# 121 Marland Rd. S

## Proposed Zoning Correction

# Markup Summary

121 MARLAND RD S.
Legal Description

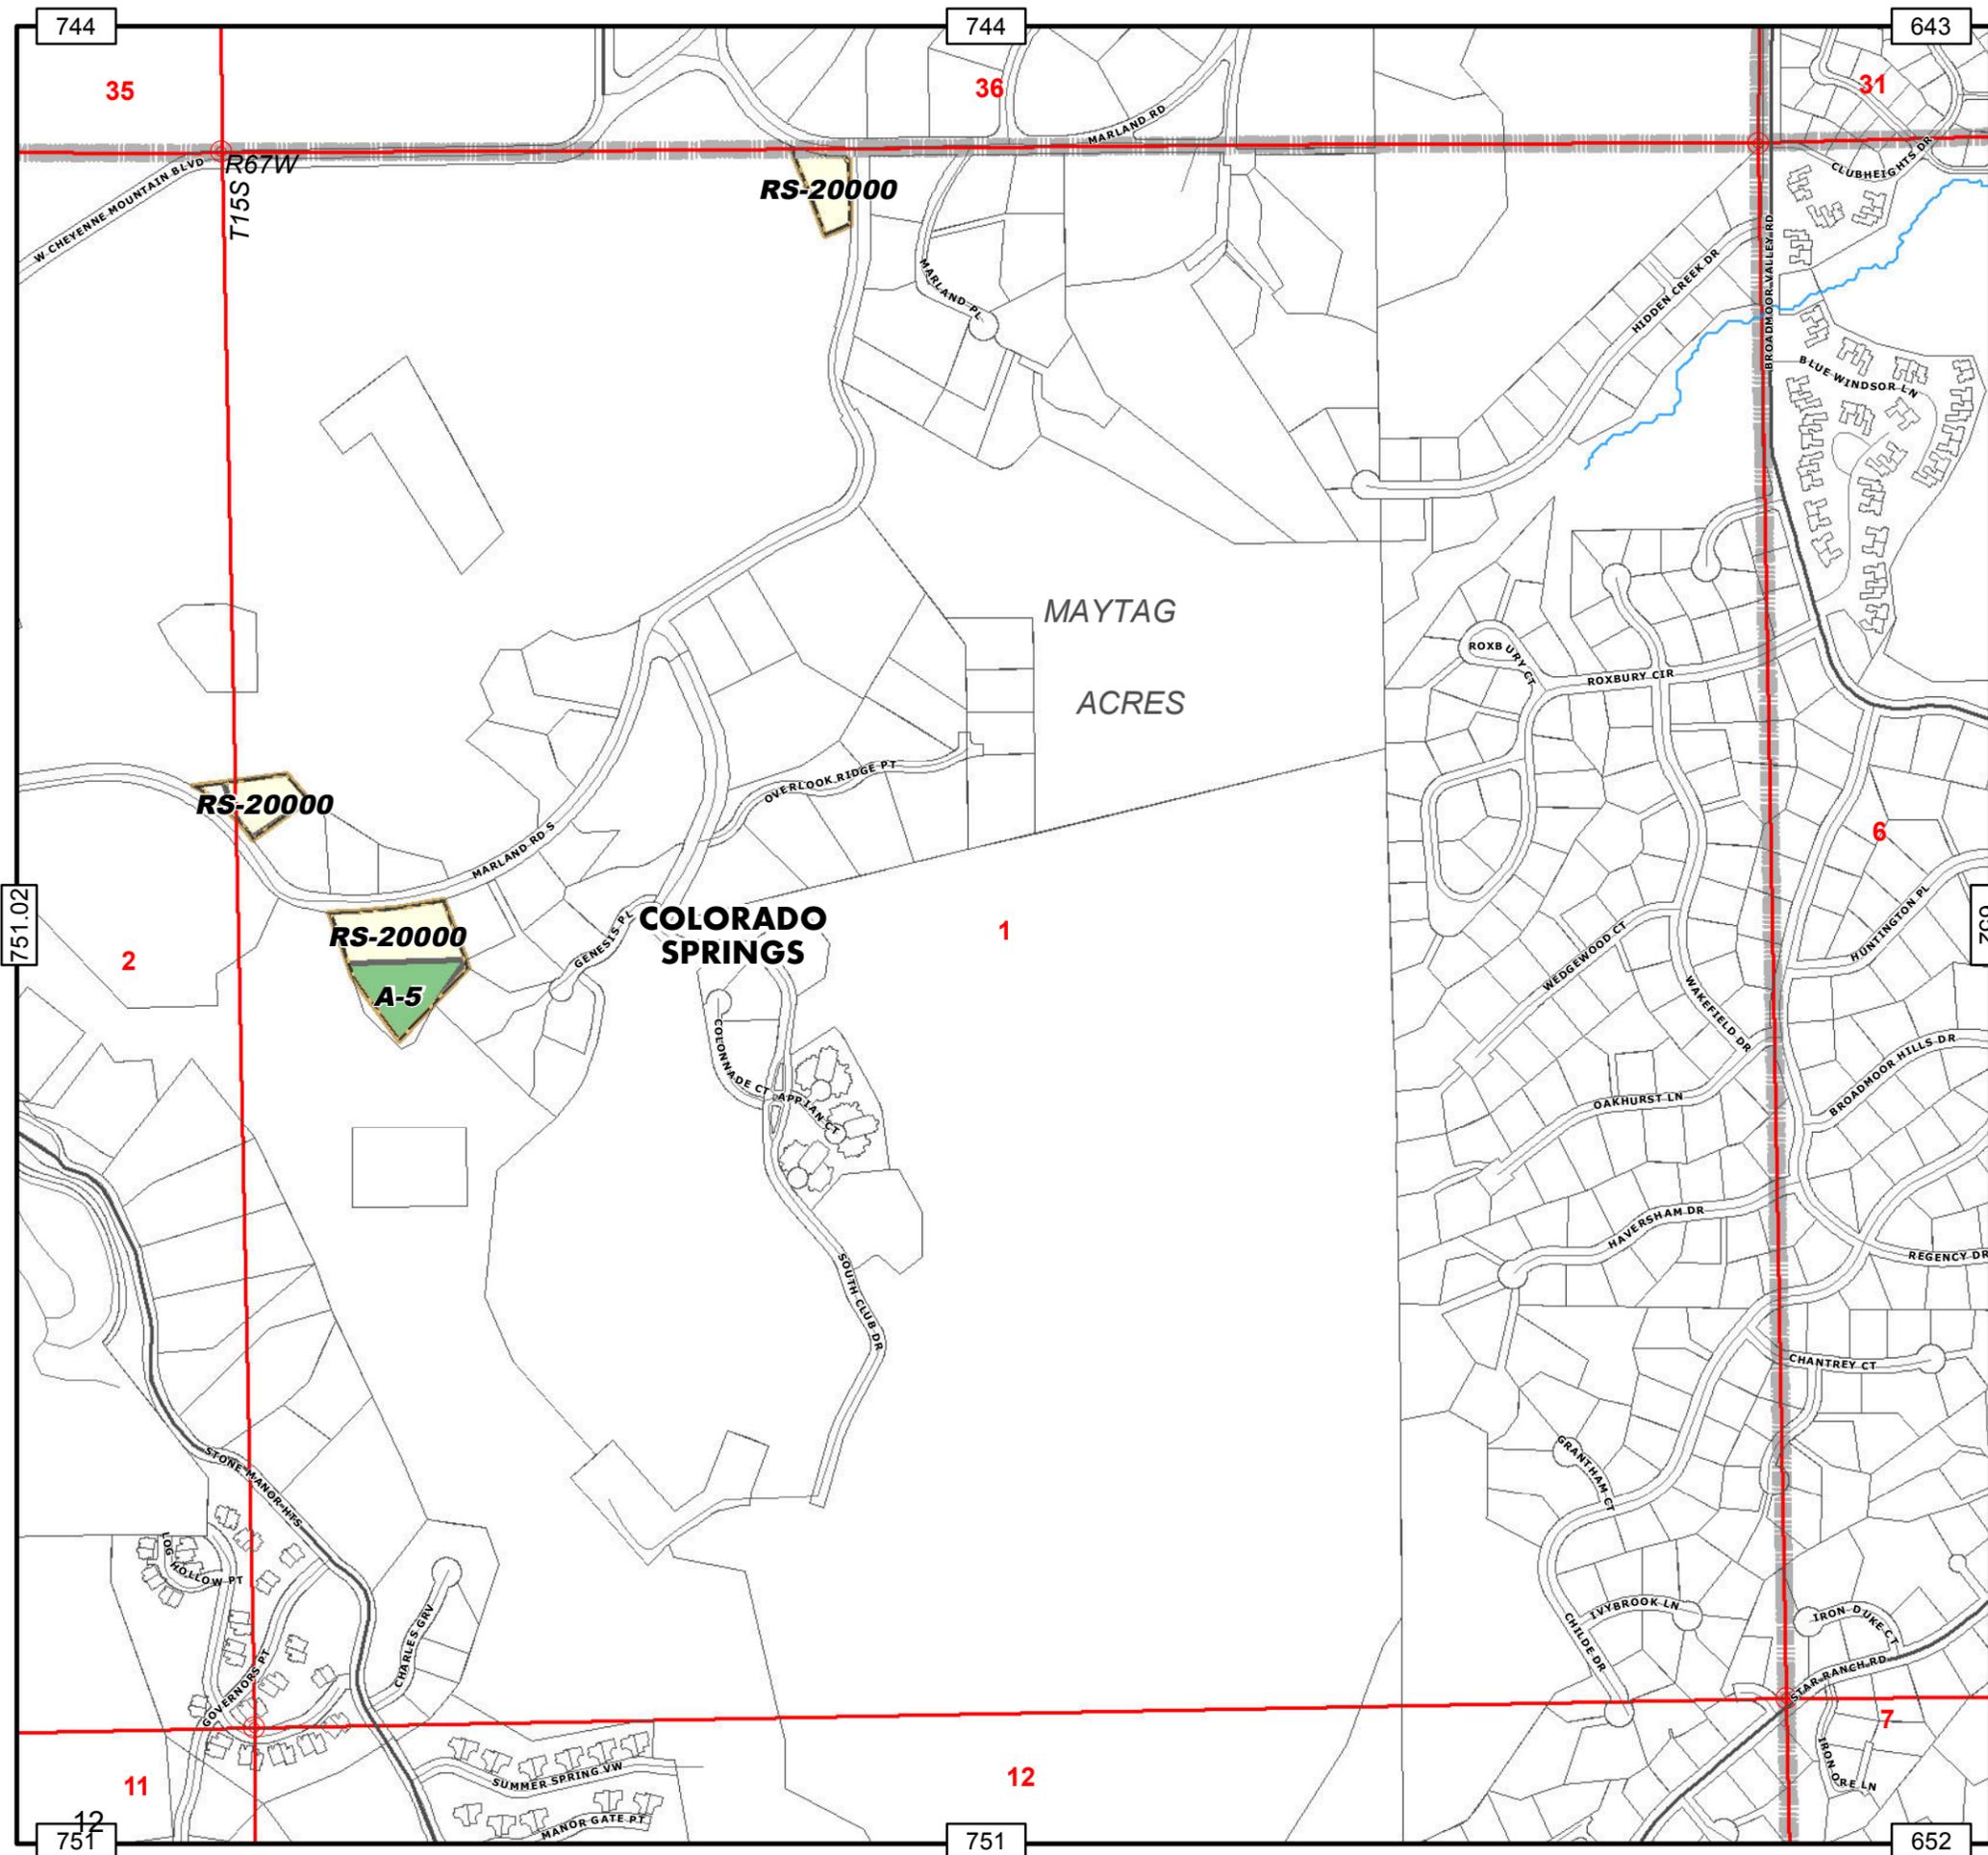
Include the legal description on hat is being rezoned, not the entire parcel, because it seems that part of the parcel is within the City of Colorado Springs' jurisdiction.

I found this checklist for rezoning maps:

1. Boundary description of the subject property, which shall illustrate the legal description.
2. Existing land use and zoning on the property and within five hundred (500) feet of the boundary.
3. Adjoining property ownership.
4. Existing private roads.
5. Existing structures.
6. Existing easements.
7. Name and addresses of the petitioner owners of all interests (including mineral interests) the property, and preparer.
